From: [REDACTED]
Sent: 23 July 2025 09:13
To: Jonathan Manhire
Subject: FW: D2339 - Regal House, Shripney - Surface Water Drainage Enquiry

Subject: D2339 - Regal House, Shripney - Surface Water Drainage Enquiry

My client intends to re-submit a new planning application for a residential development and we are tasked with delivering the drainage strategy to which we now require some confirmations from WSCC as outlined below.

Drawing Code	Drawing No.	Rev.
000-BPC-WD-ZZ-D-C	PL003	P01

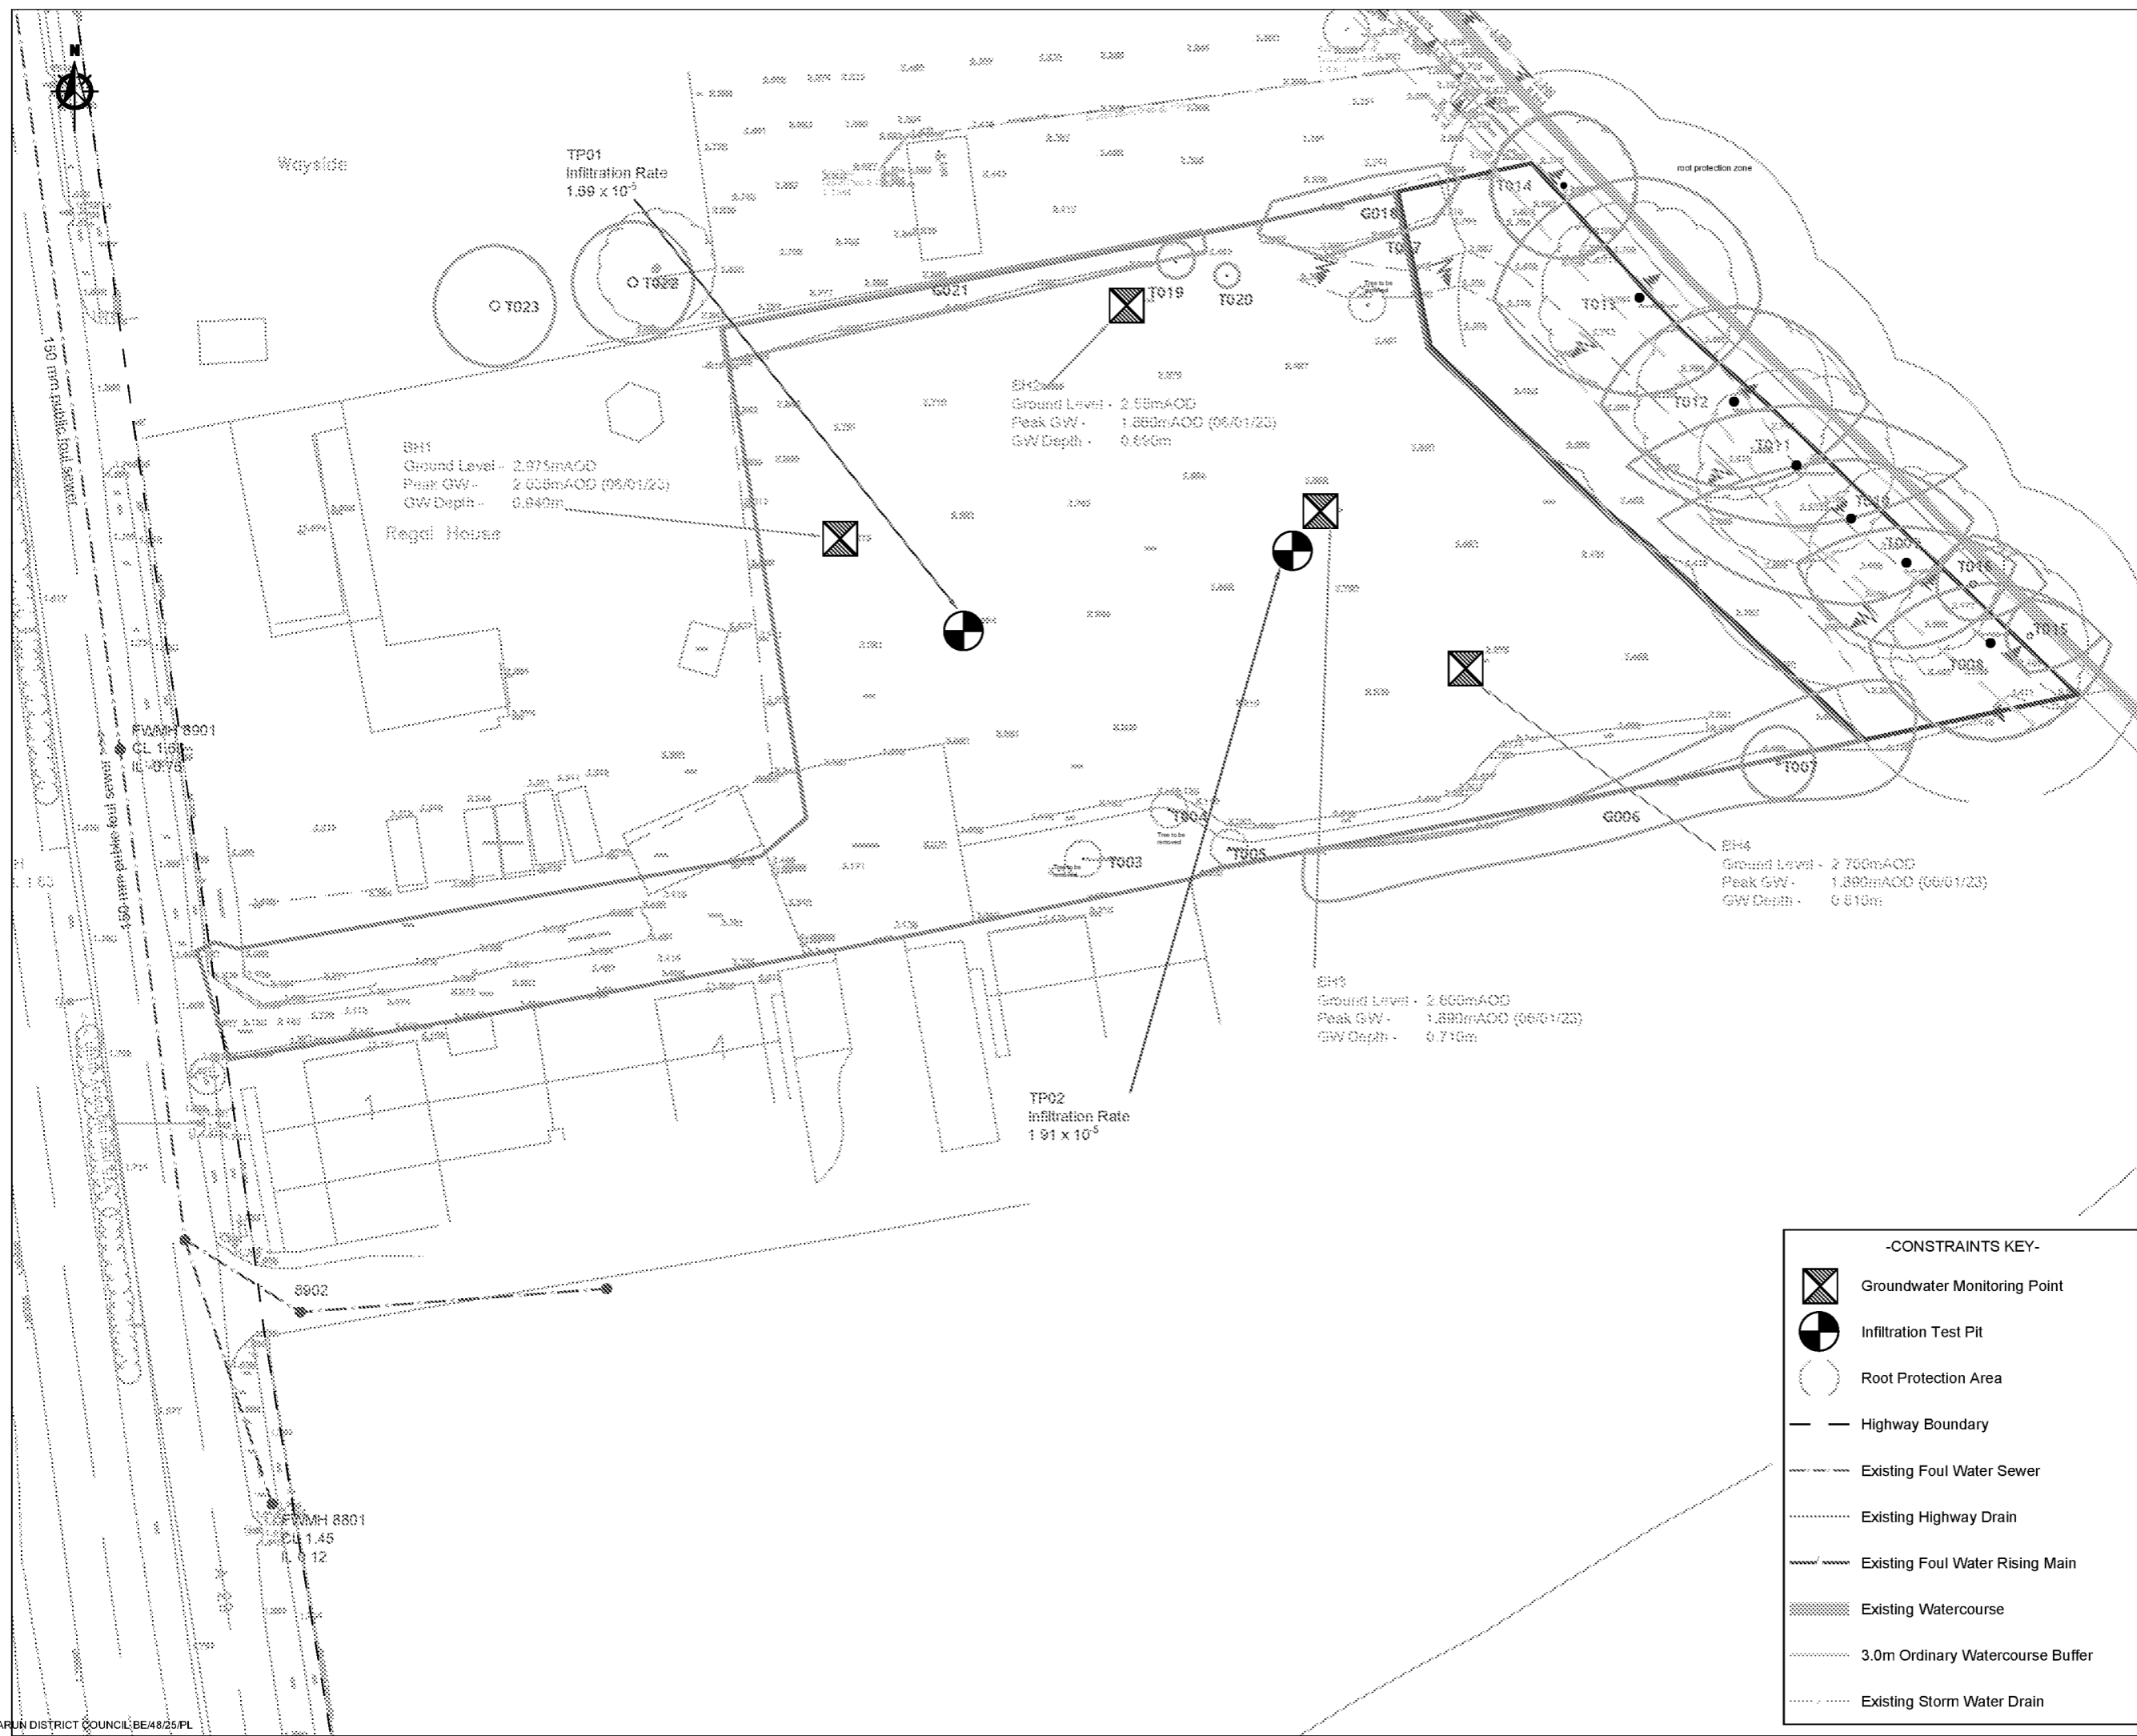
However, I have discussed your option 2 with Paul Cann. Paul is of the view that this site must mimic the natural catchment areas, and therefore a connection to the eastern ditch is required. **Only the very front section (access) of the site can drain west.**

As you are aware, ADC have reviewed the current planning application and 3rd party drainage strategy where geotechnical testing evidenced a high groundwater (outside the winter months), therefore ADC have stipulated that infiltration techniques are not viable for this site. This information is replicated on drawing PL003 with other known constraints.

Happy with your current proposals for outline planning.
